Katherine Powell, Case Leader
Infrastructure Planning Commission
Temple Quay
Bristol
BS1 6PN
24th February 2012
Ref A556 Road Scheme

Having investigated further I wish to register my further concerns and objections as I firmly believe this is a very **Unfair Consultation** particularly in view of the fact that the Infrastructure Planning Commission (IPC) requires the Highways Agency to undertake an **“adequate public consultation”**

Cuttings and embankments

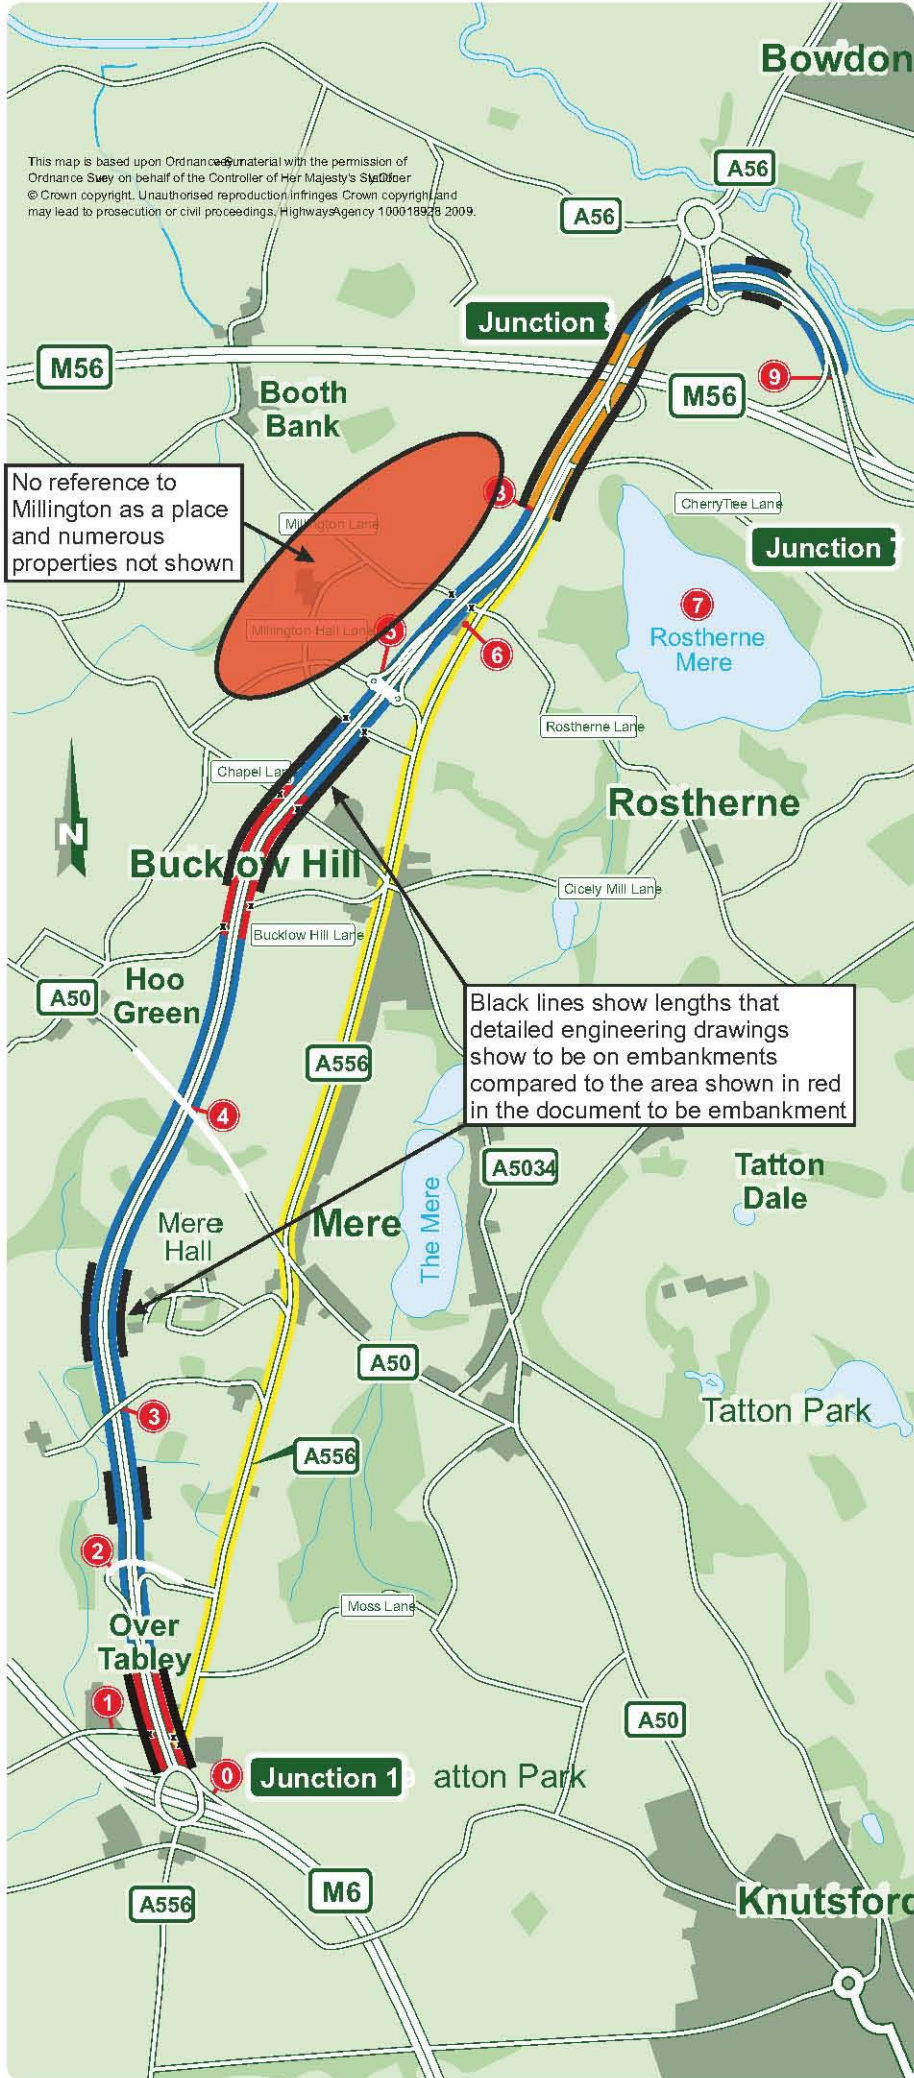
The diagrams illustrate all of the properties at Mere but don't acknowledge the properties to the west of the road, and the numerous maps at the Public Exhibition confirm that **cuttings** were to be provided along the majority of the route (promised in 2007) which actually appear in the PCSD diagrams, **will not, actually** be, provided.

~~This~~ link road would become unnecessary if the cuttings which we were promised in 2007 were actually provided local people would continue to use chapel lane, Millington hall lane and Millington Lane passing over the new road in its cutting, clearly the **removal of the cuttings** is totally unacceptable in terms of both the environmental impact and local access.
